Application No: FP/9/26/HH
Site Address: 4 Davenport Road Felpham PO22 7JP
Description of works: Garage conversion and external and internal alterations to existing dwelling.

Thank you for your internet representation made on 4th February 2026 which has been recorded as no objection with the comments as follows:

DRAWING
**PROPOSED
ELEVATIONS**
DRAWING No
462/05
REVISION
SCALE 1:100
DATE DEC 2025
DRAWN LA
CHECKED

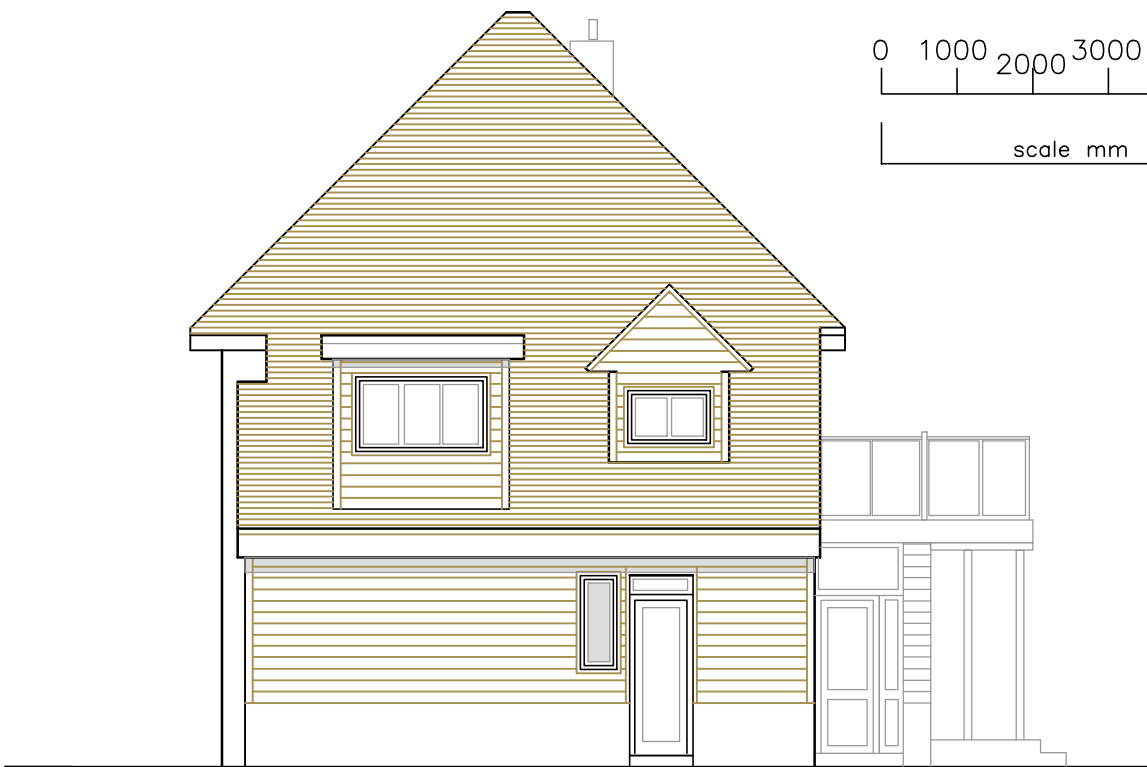
Felpham Parish Council has no objection to this application.
Note: Note: Concerns regarding volume of glass adjacent to boundary.
